CITY OF PORTLAND
Planning and Urban Development Department

MEMORANDUM

RE: Temporary Certificate of Occupancy for 100 Beverly Street

I have reviewed the single family residence at 100 Beverly Street and believe it would be acceptable to issue a temporary Certificate of Occupancy. A permanent Certificate of Occupancy should not be issued until the following conditions have been met.

PLAN SHOWING A PORTION OF WOODFORDS GARDENS

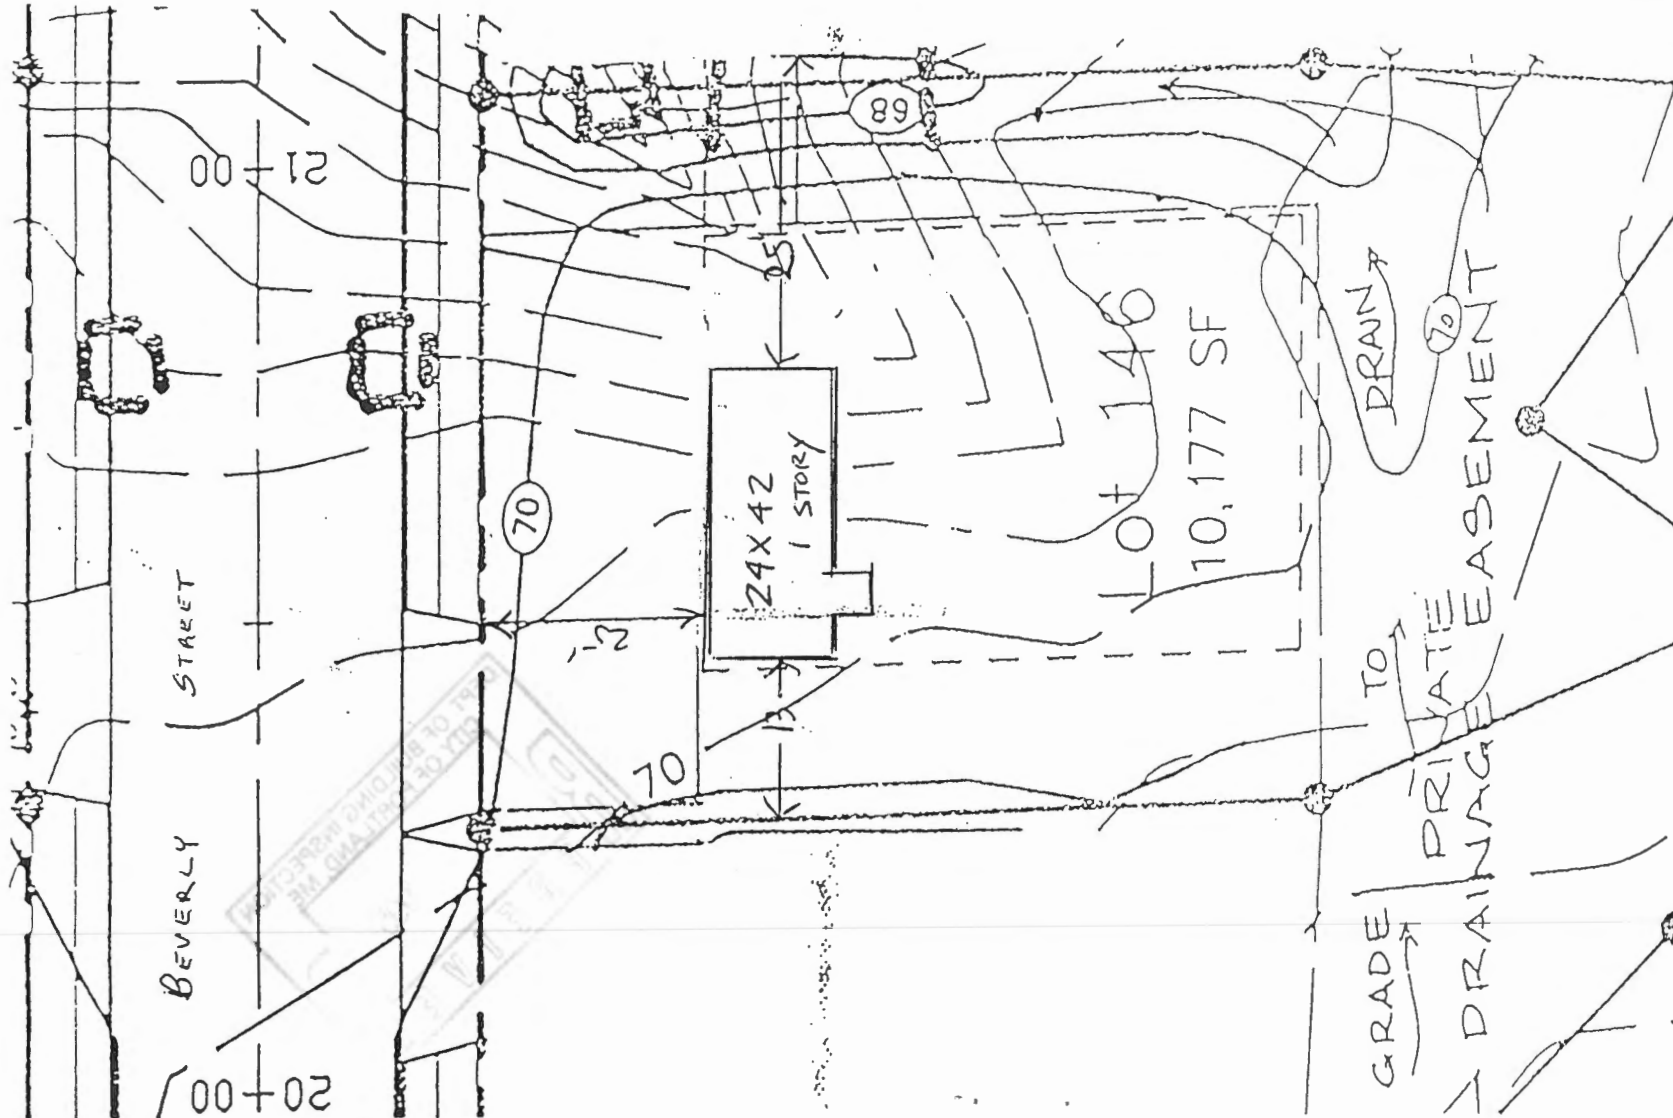
1. At the time of my inspection, the ground surface was covered with 2 feet of snow making it difficult to review the lot grading. It appears that lot grading may be necessary in the spring. There may be a problem with the bulkhead elevation of the house. This elevation of the bulkhead should be 6 inches higher than the ground and be graded to conform to the natural grade and provide positive drainage away from the house. A swale is also necessary to provide positive drainage for off-site flows crossing the rear of the lot.

4. Erosion control fencing or approved equal shall be installed along the drainage easement swale and across area subject to shallow flows. All erosion control measures shall be installed as soon as the ground is thawed enough to properly set in place. Measure must be in place prior to April 1, 1996.
